Our Ref: FP/162/18/HH
Your Ref:

Town & Country Planning Act 1990 (as amended)
Town & country Planning (Development Management Procedure) (England) Order 2015
Application for Planning Permission for Works or Extension to a Dwelling

Development Demolition of existing front & rear projections & erection of front & rear single storey extensions plus front & rear dormer projections to existing first floor.
Location 9 Roundle Road Felpham

Proposed

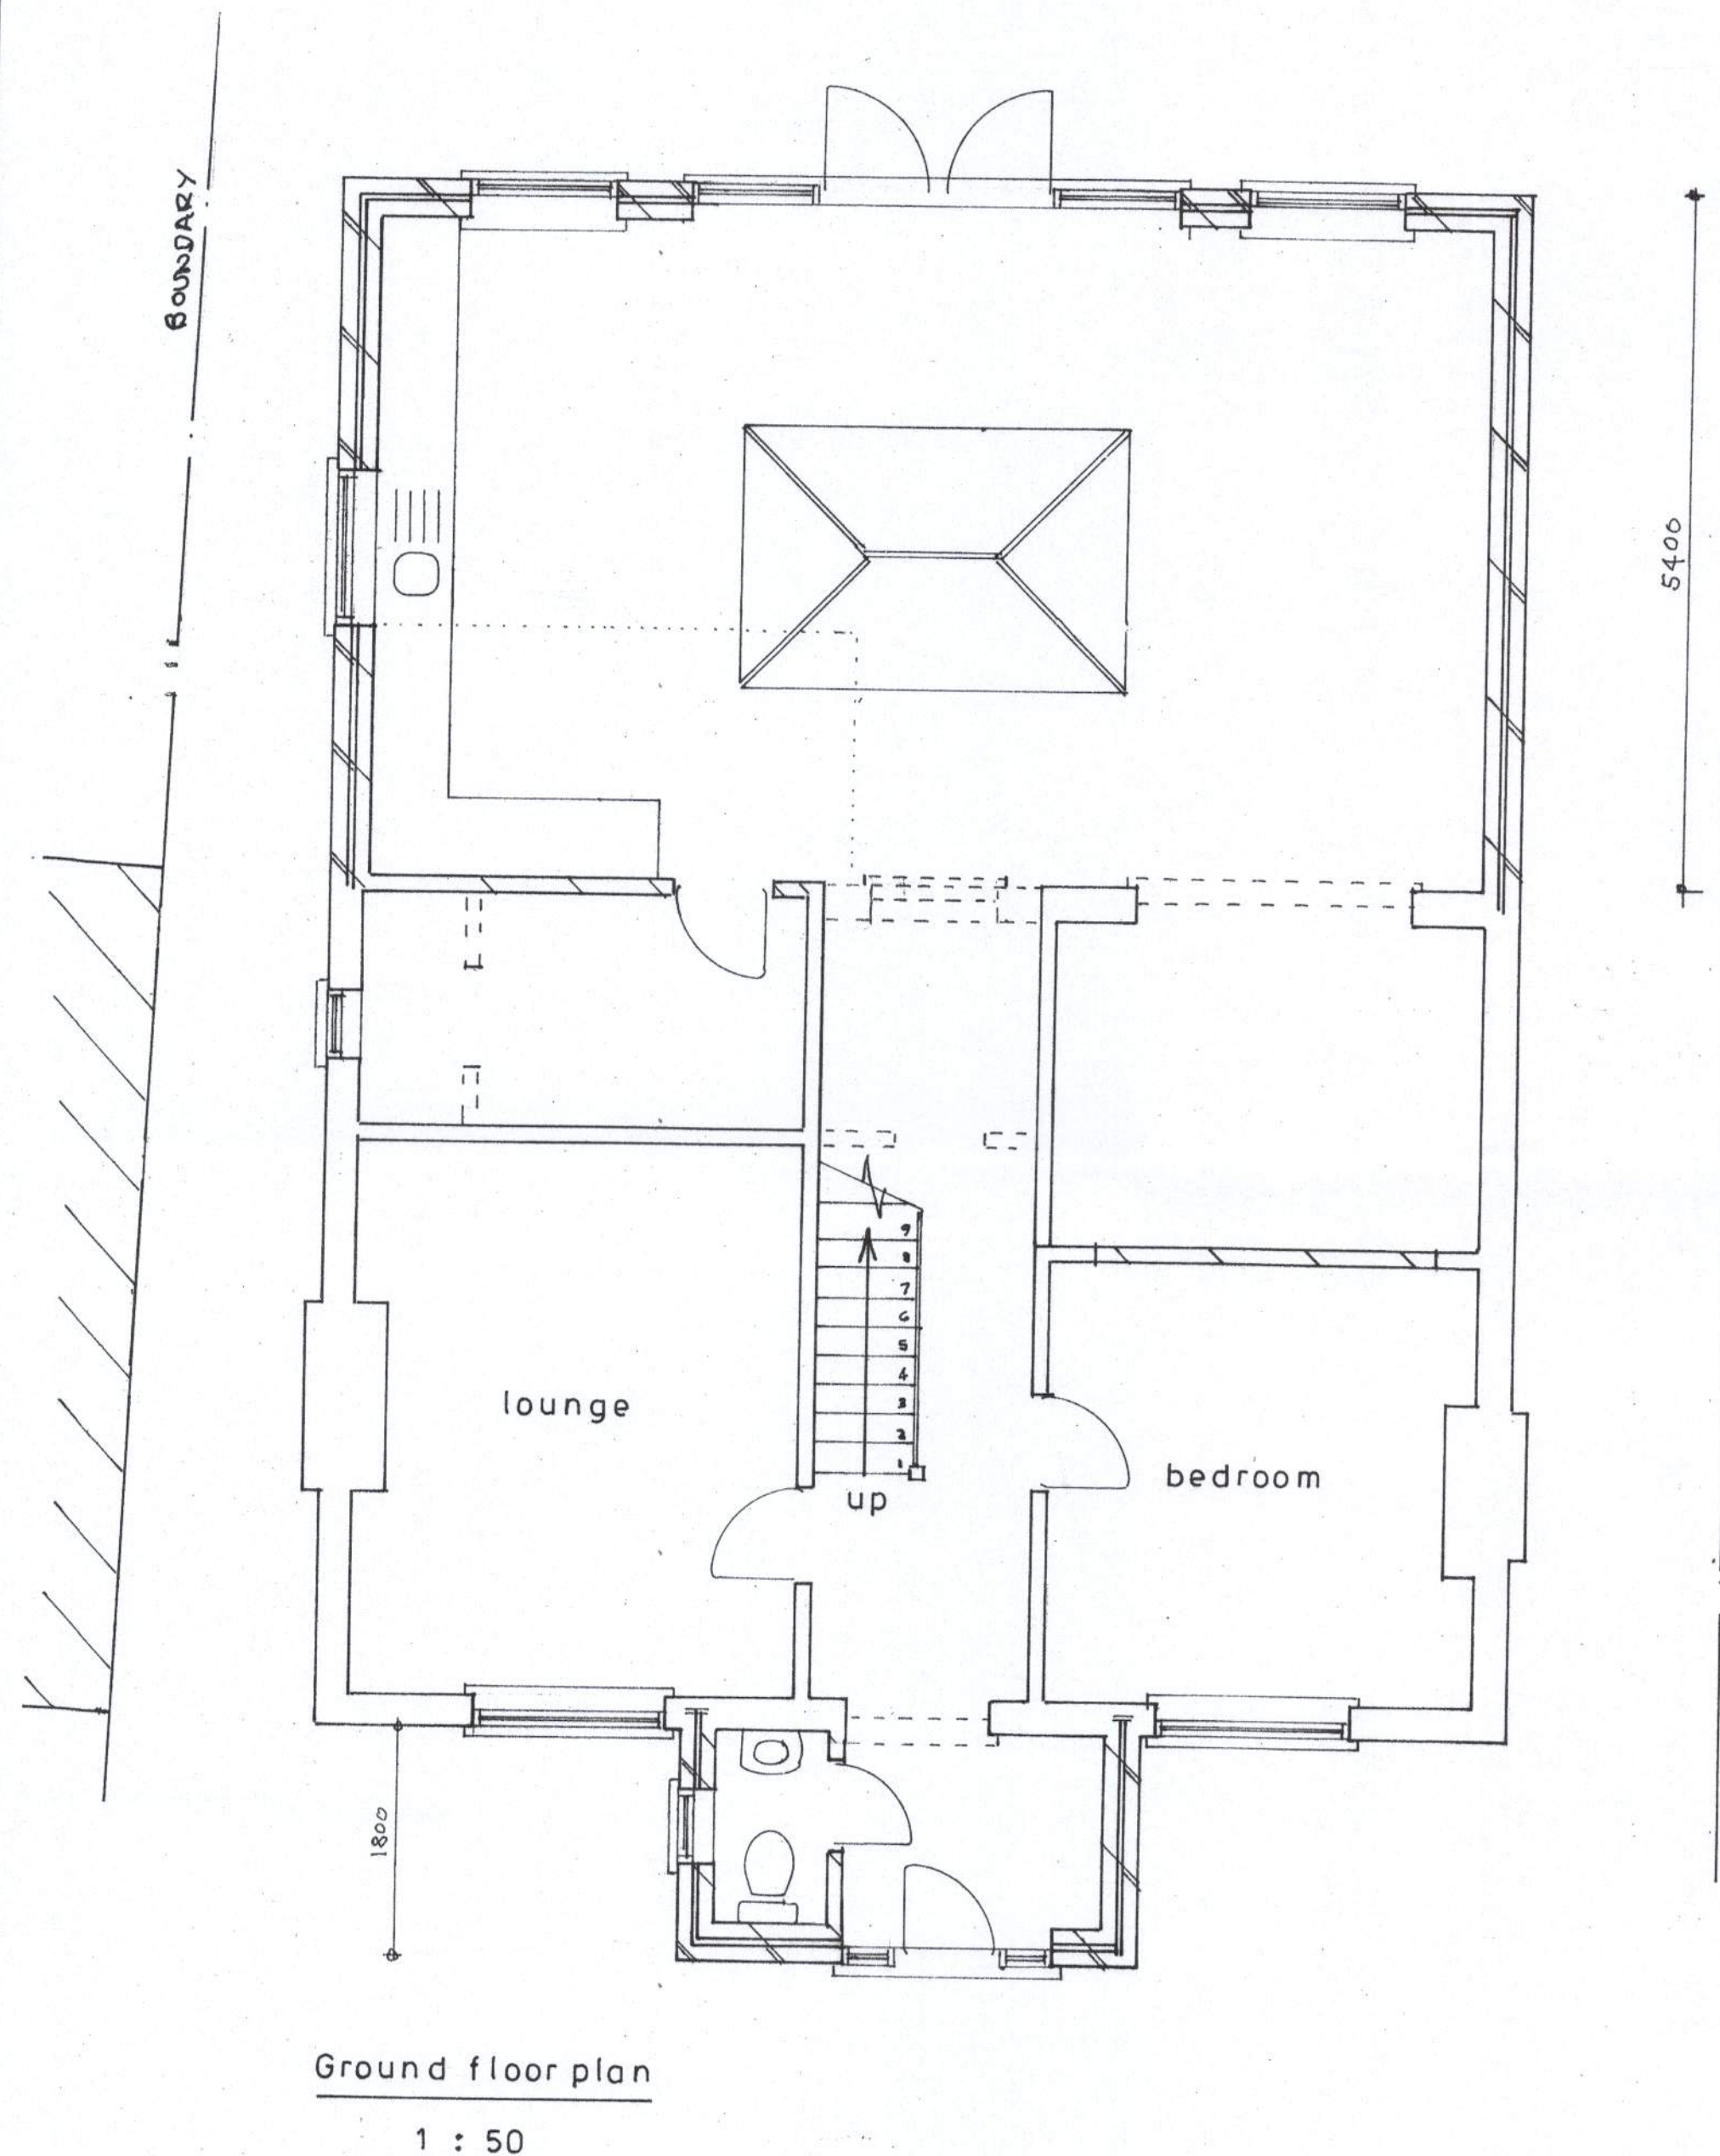
The existing and proposed ground floor east elevations and floor plans do not accord. Please amend accordingly.
